This consult is in reference to Miscellaneous SEPA Applications SE-23-00016 *Ritter*. Ground disturbing activities include the grading and construction of a road, the SEPA document

RE: 202304350; SE-23-00016

SUBJECT: SE-23-00016 Ritter Access Road

TO: All Staff
FROM: Public Works Plan Review Team
DATE: September 27th, 2023
SUBJECT: Public Works Comments: SE-23-00016 Ritter

NEW ROAD PROPOSAL -
APPLICANT -
JIM RITTER, POA
FOR WILLIAM P. WOODS, JR.
E-MAIL - JAMESRITTER@GMAI.
206-949-9143.

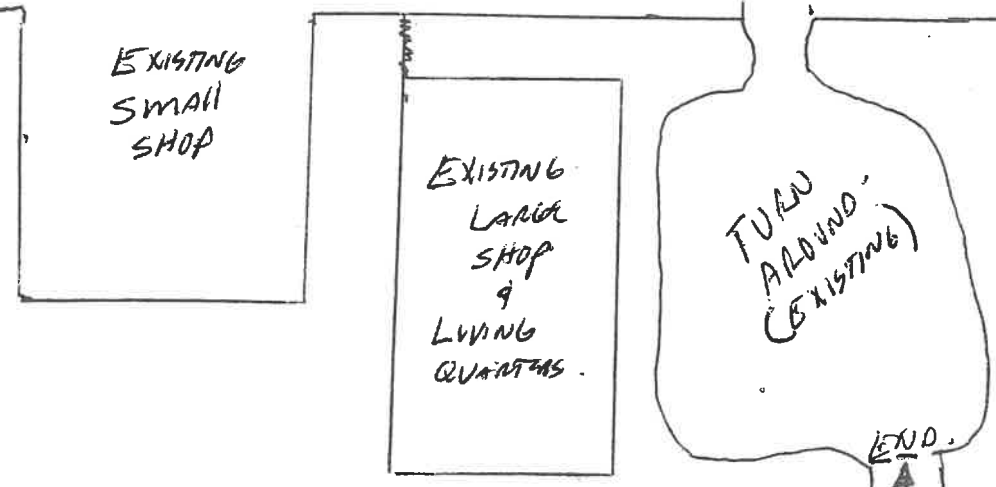
We encourage further review of how the road, as proposed, may impact critical areas such as frequently flooded areas and wetlands.

SURVEY	<p>The current lot configuration has the existing large shop on Parcel #664234, with the proposed access crossing over Parcel #10847.</p> <p>This will have to be resolved by either a Boundary Line Adjustment to match the lot lines shown on the site plan, with the Large shop on Parcel #10847, or by a "Reservation of Easement" over Parcel #10847 for the benefit of the Large Shop on Parcel #664234.</p>
TRANSPORTATION CONCURRENCY	No comments
FLOOD	Parcels 10847 and 664234 are not mapped in the FEMA identified special flood hazard area (100-year floodplain). (SC)
WATER MITIGATION/ METERING	No comments. (SC)
